## REPRESENTATIONS TO THE PROPOSED MANSTON AIRPORT DEVELOPMENT CONSENT ORDER APPLICATION PINS REF: TR020002

Deadline 9 Submission

Iceni Projects Limited on behalf of  
Cogent Land LLP

Manston Airport Development Consent Order  
Regulation 5(2)(i)(i), (ii) and (iii) – Land Plans  
Sheet 4 of 5  
Thanet District Council

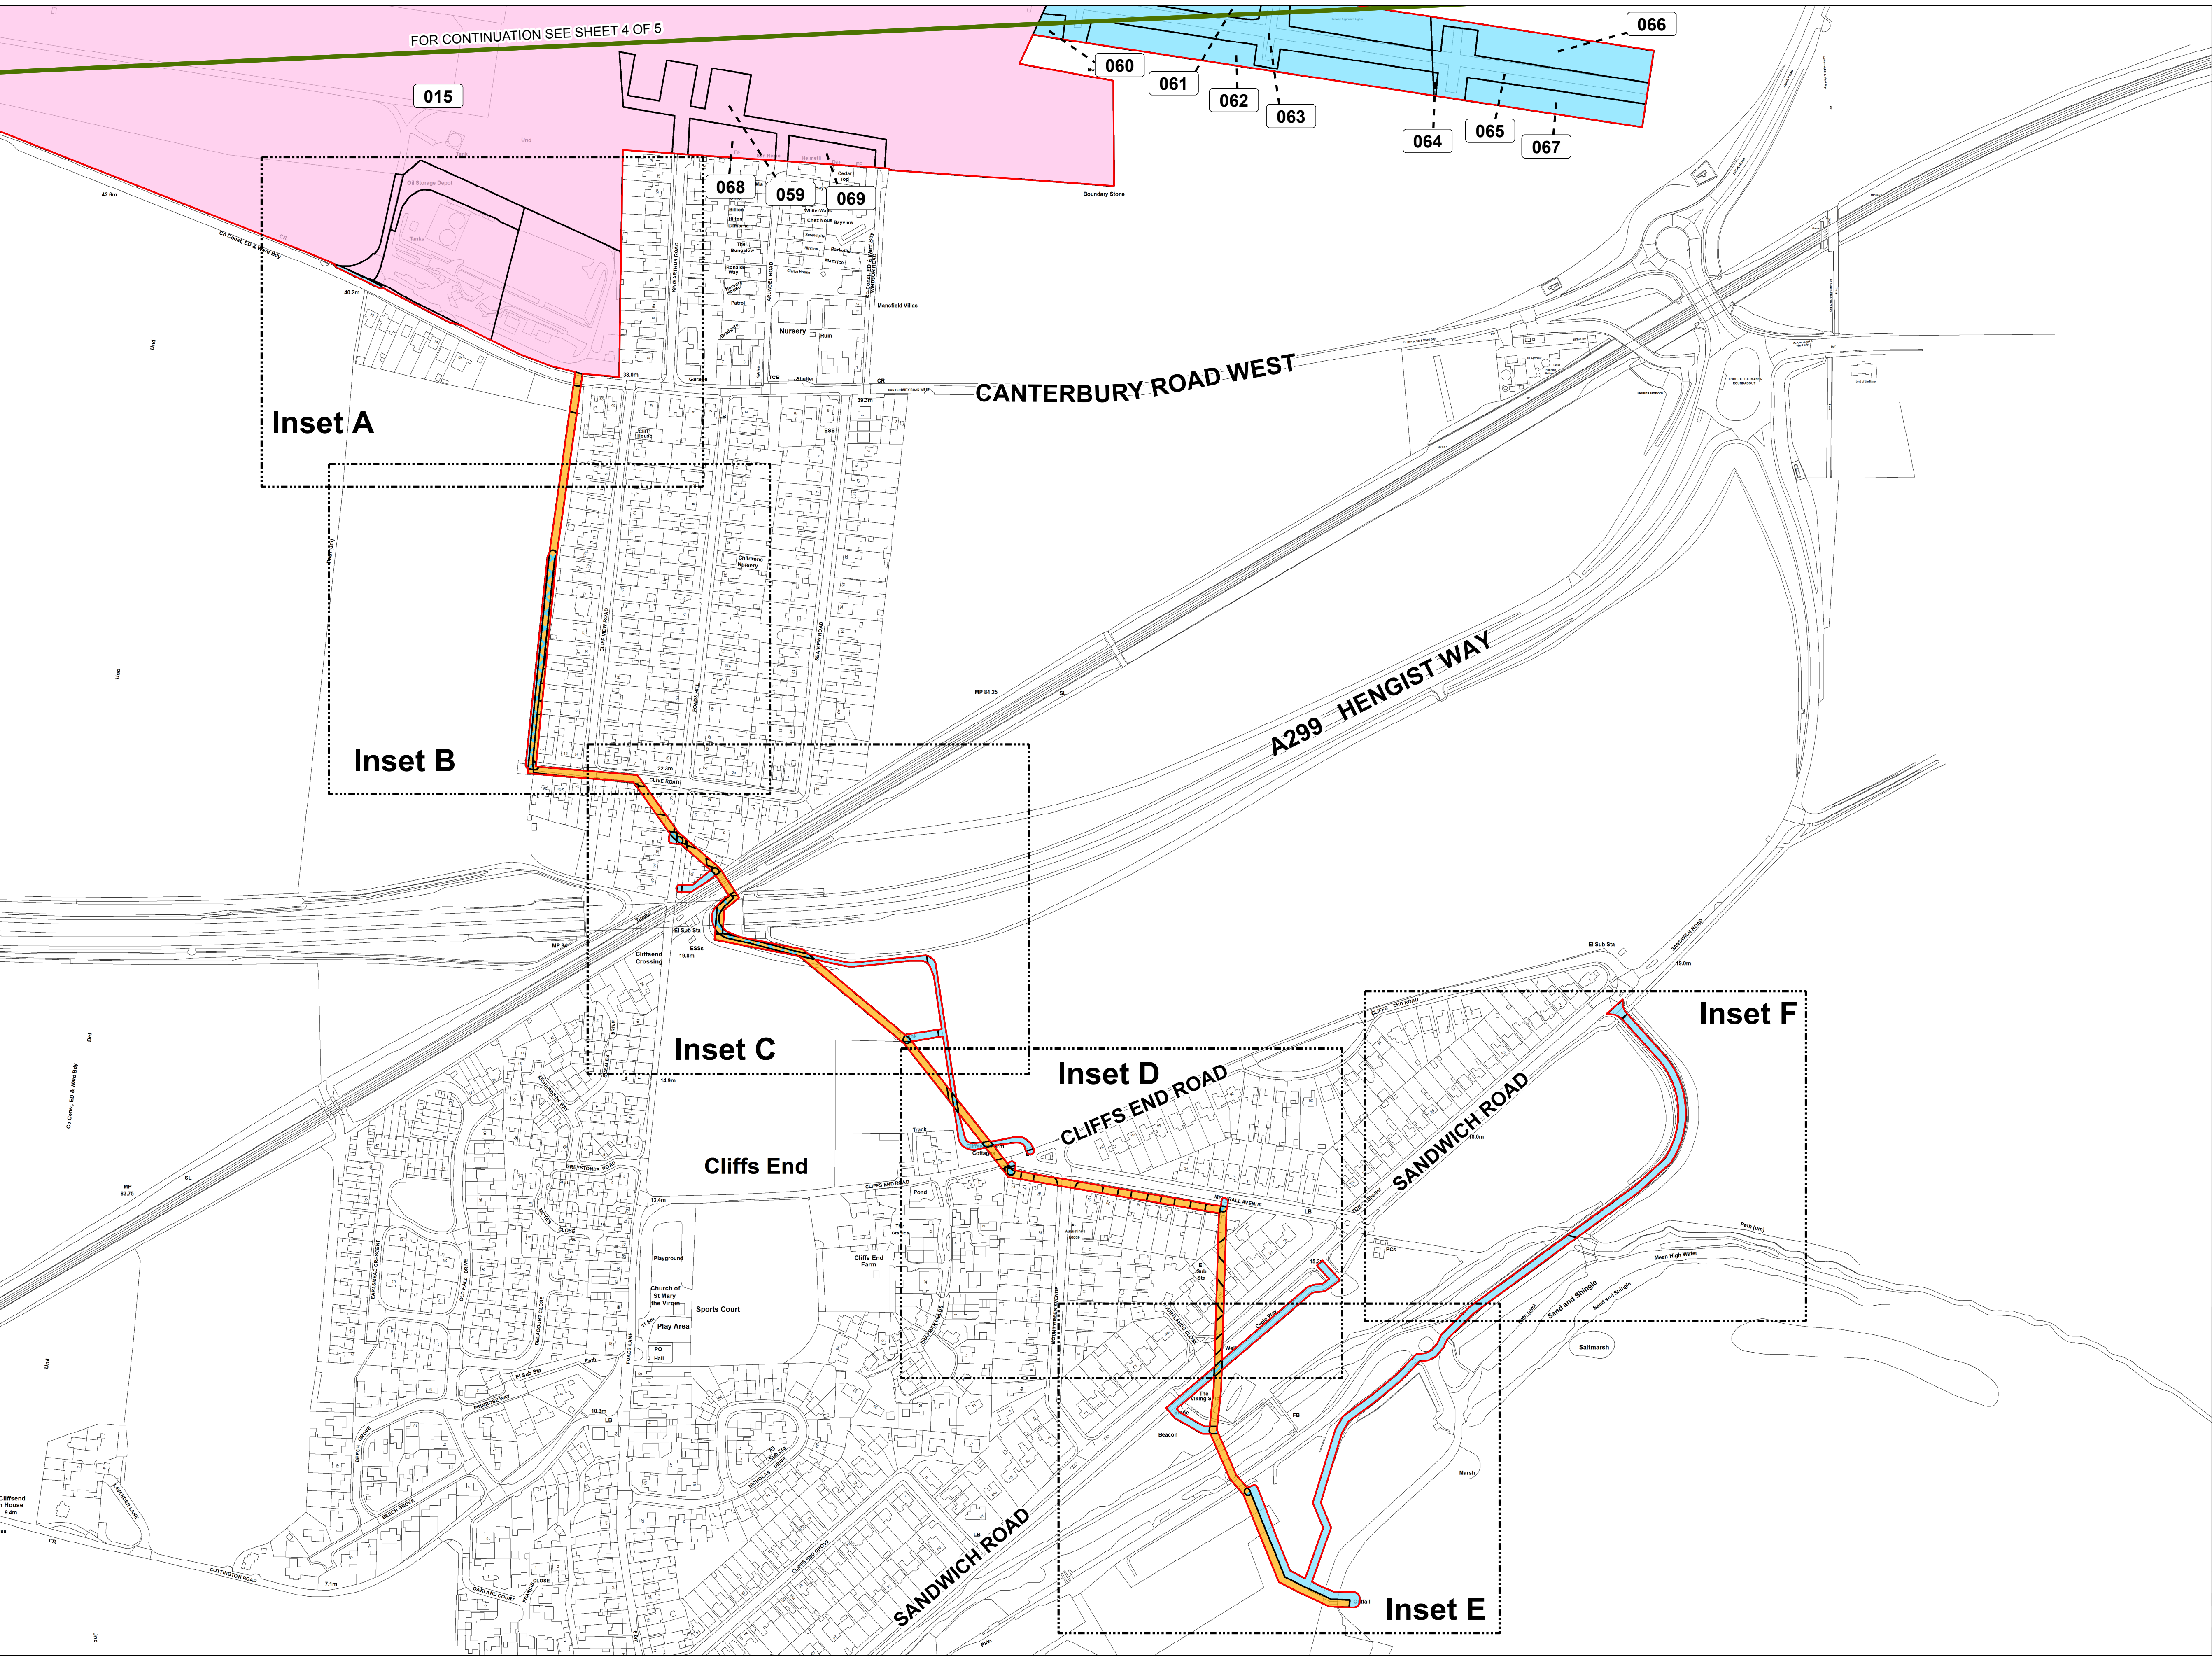
- 3.2 Due to the proximity of the Manston Green site to the DCO application boundary a portion of the site to the west is subject to a CPO acquisition of the permanent rights over the land (as shown on sheet 4 of TR020002/APP/4.2 Land Plans)<sup>2</sup>.

- 3.3 Table 18.4 of the ES for the DCO Scheme states that *"The Manston Green site [Site ID 143] overlaps with a small section of the Proposed Development red line boundary. In this location, the Proposed Development will be used for landing lights only, and the lights are unlikely to extend to the far eastern extent of the boundary. The area of overlap in the outline masterplan for Manston Green is shown as open space and a new link road"*. It should also be noted that this is an area of land that is also required for drainage purposes and this is shown on the masterplan for Manston Green.

- 3.4 The Applicant is clear in their response to the ExA's First Written Questions (TR020002/D3/FWQ) that they are seeking the acquisition of the permanent rights to the land only<sup>3</sup>. As indicated above, this area of land is to be used for the landing lights only, however, no further information in relation to construction, maintenance and access requirements for the lights is provided within the DCO documentation. Furthermore, although the ES states that *"the lights are unlikely to extend to the far eastern extent of the boundary"* there are no detailed plans showing the exact extent of the lights. If physical infrastructure, such as the cables, columns to support the lighting etc., is required within the

- 3.6 This section of CPO land falls within the proposed drainage area for Manston Green, and is located within Source Protection Zone 1. Appendix G of the Surface Water Drainage Strategy<sup>4</sup> submitted for the Reserved Matters application for Phase 1 of the Manston Green outline consent shows an indicative permanent / adoptable surface water sewer in this location which is required in order to deliver the Manston Green development.
